CITY OF ALBUQUERQUE

**Re: New Mexico Cancer Center Addition, 4901 Lang Ave. NE,
(D-17/D003V1)
Approval of Permanent Certificate of Occupancy,
Engineer's Stamp Date 1/05/2007
Certification dated: 1-14-08**

**Re: NM Cancer Center Addition/Remodel Grading and Drainage Plan
Engineer's Stamp dated 7-27-06 (D17/D3V1)**

GRADING AND

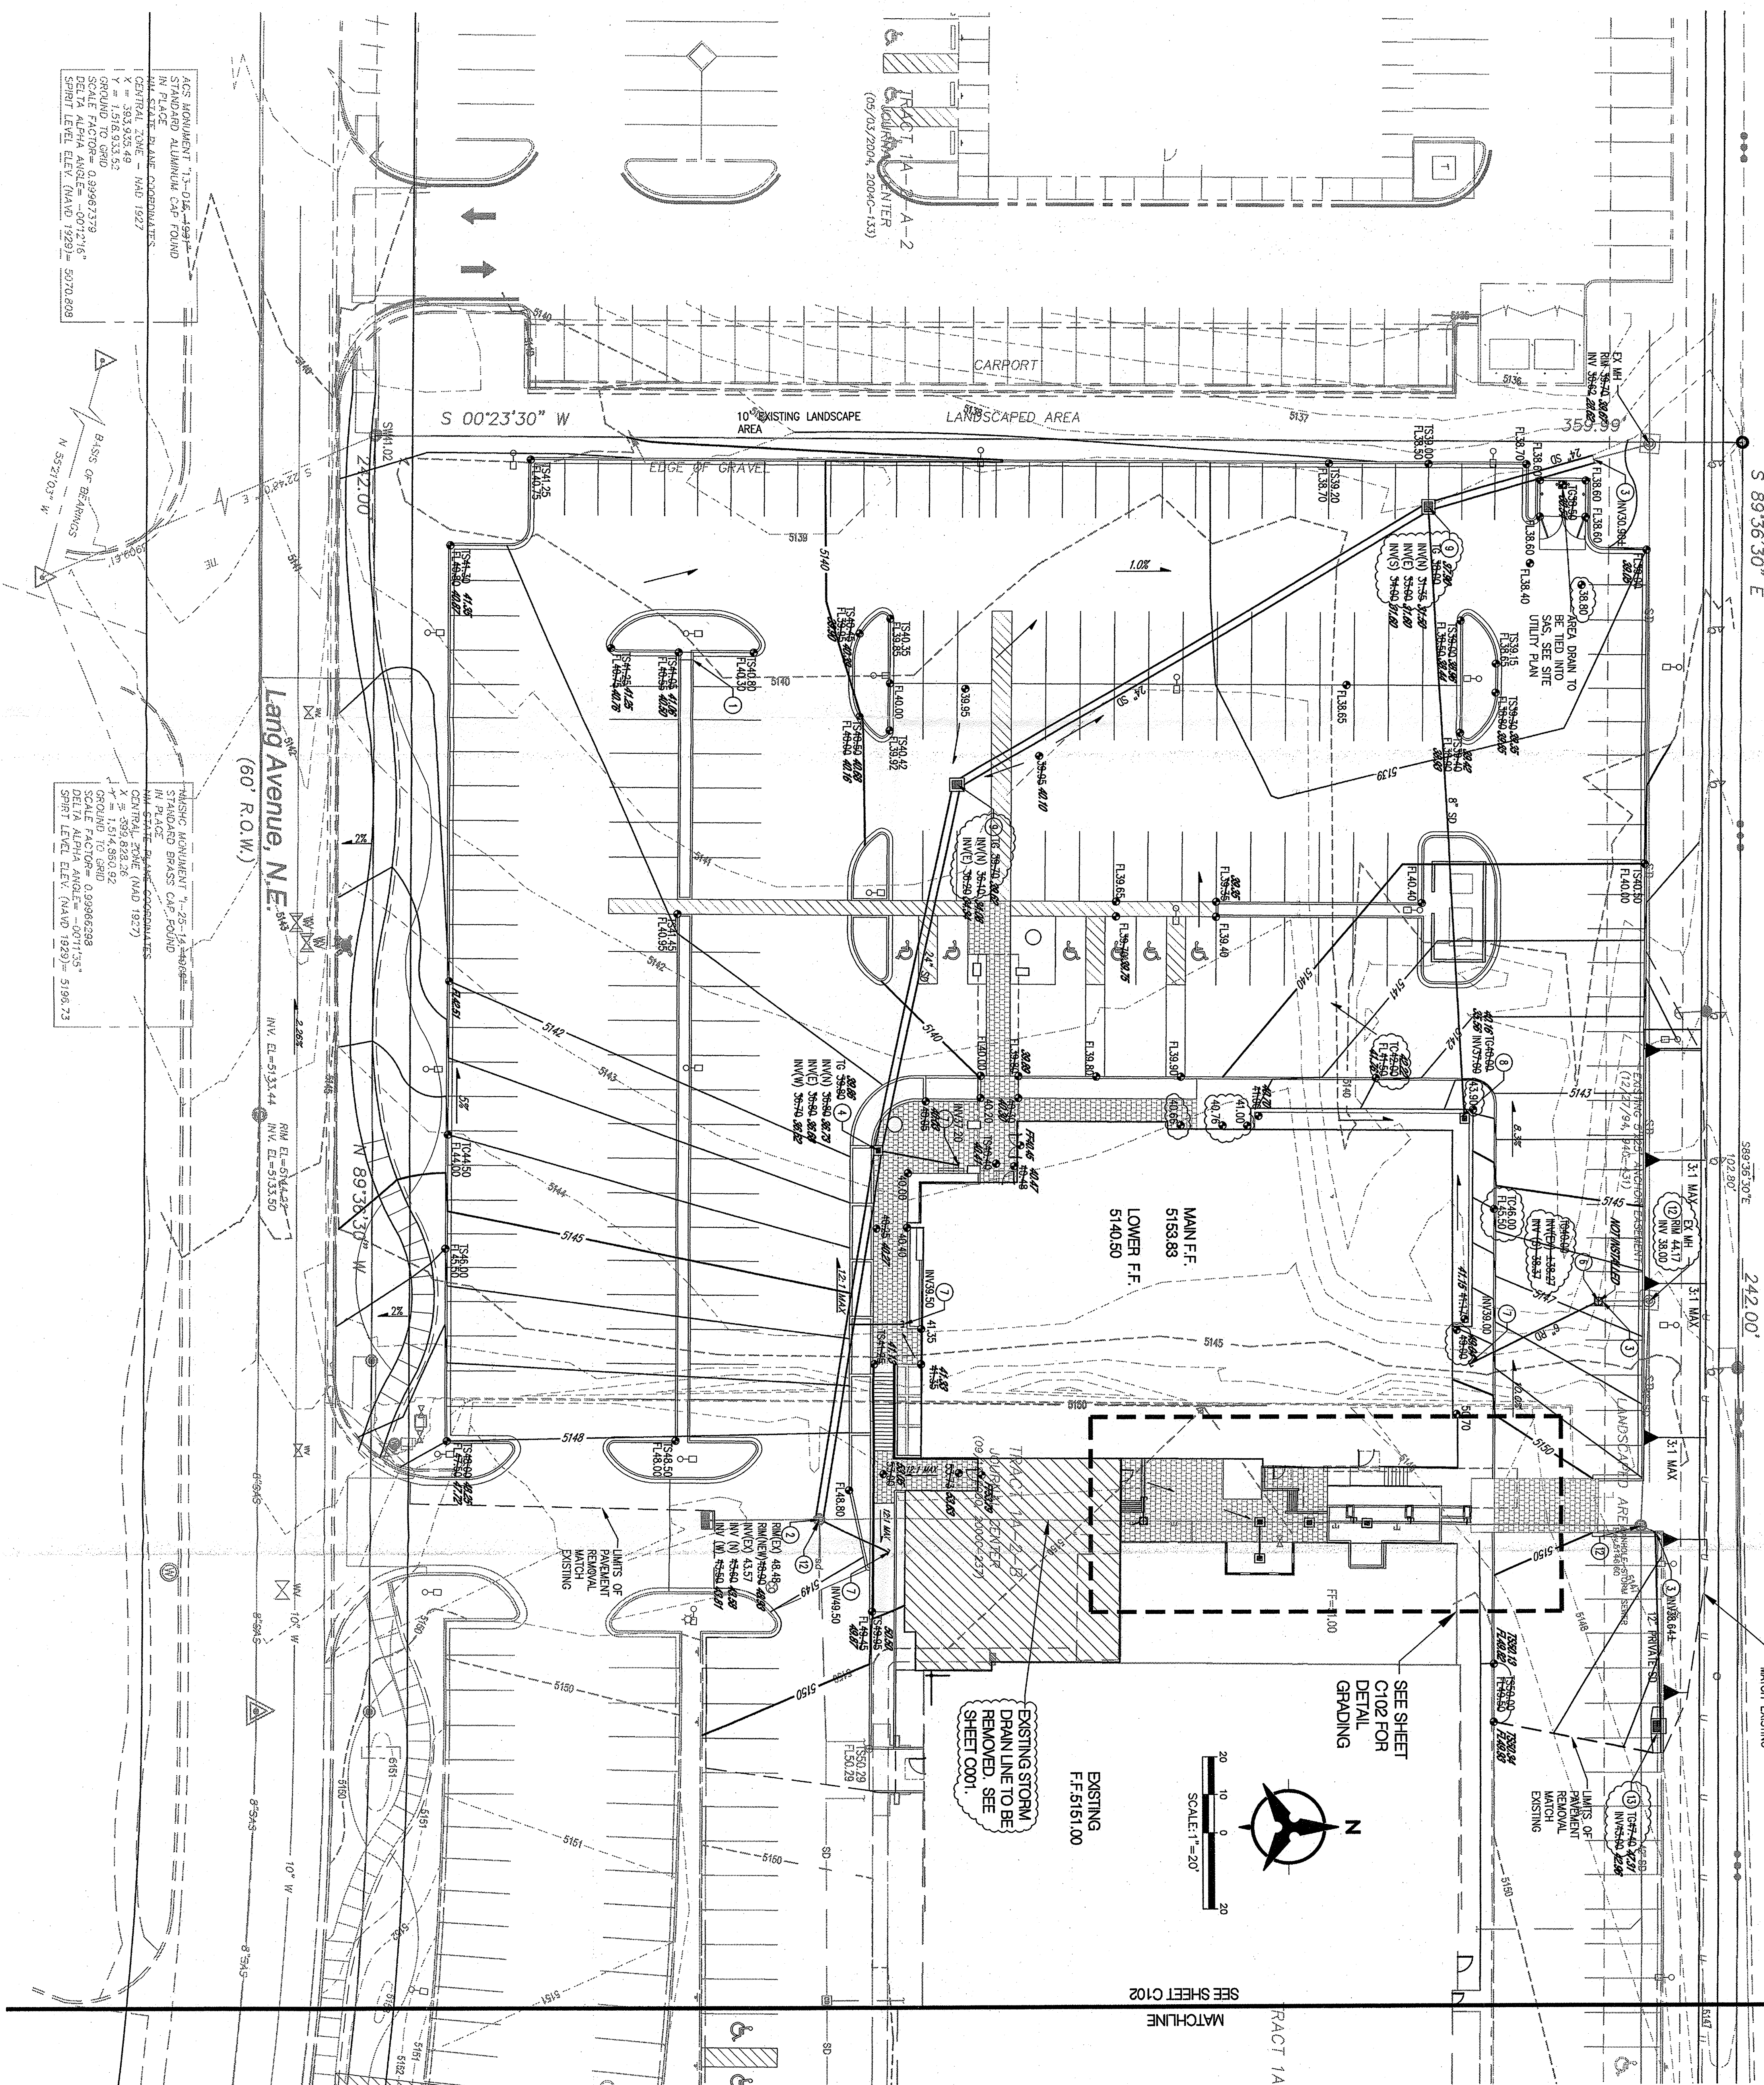
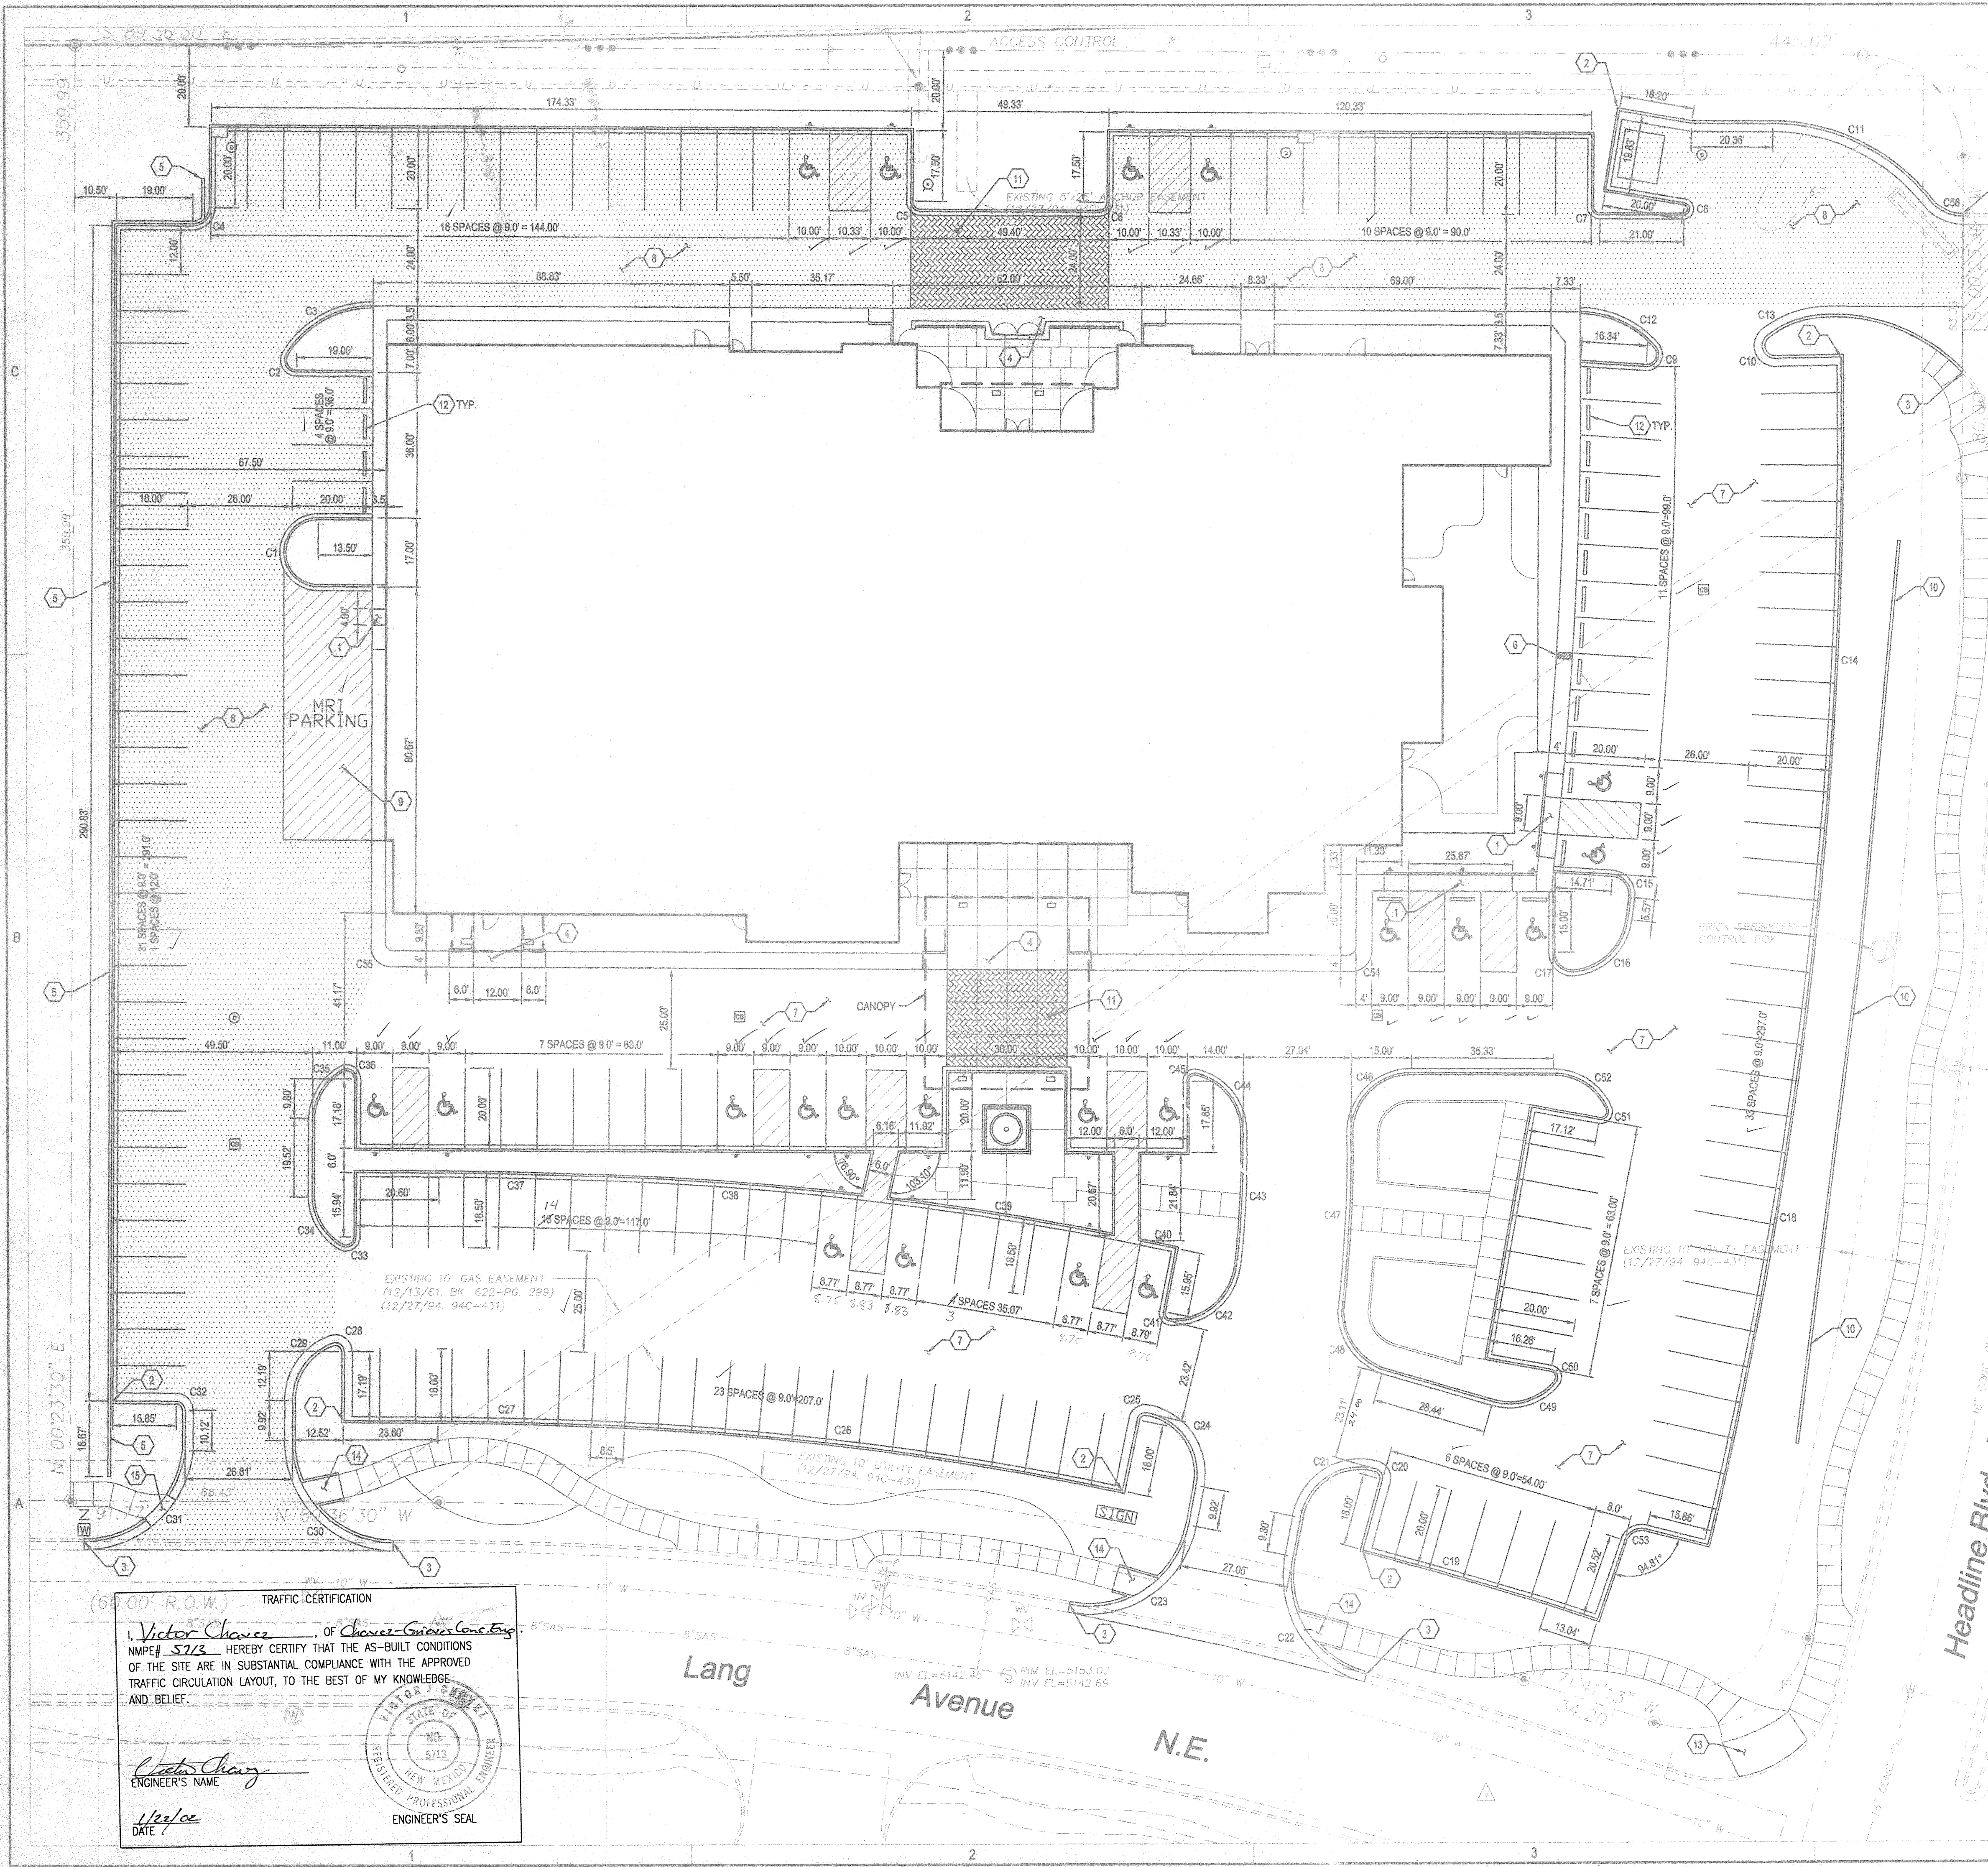
- Structures are not permitted in public easements. Please show this easement in the next submittal.
- A new agreement and covenant will be required.
- It appears that runoff will pond at the northwest parking island.
- Provide a grate height and invert for IN3.
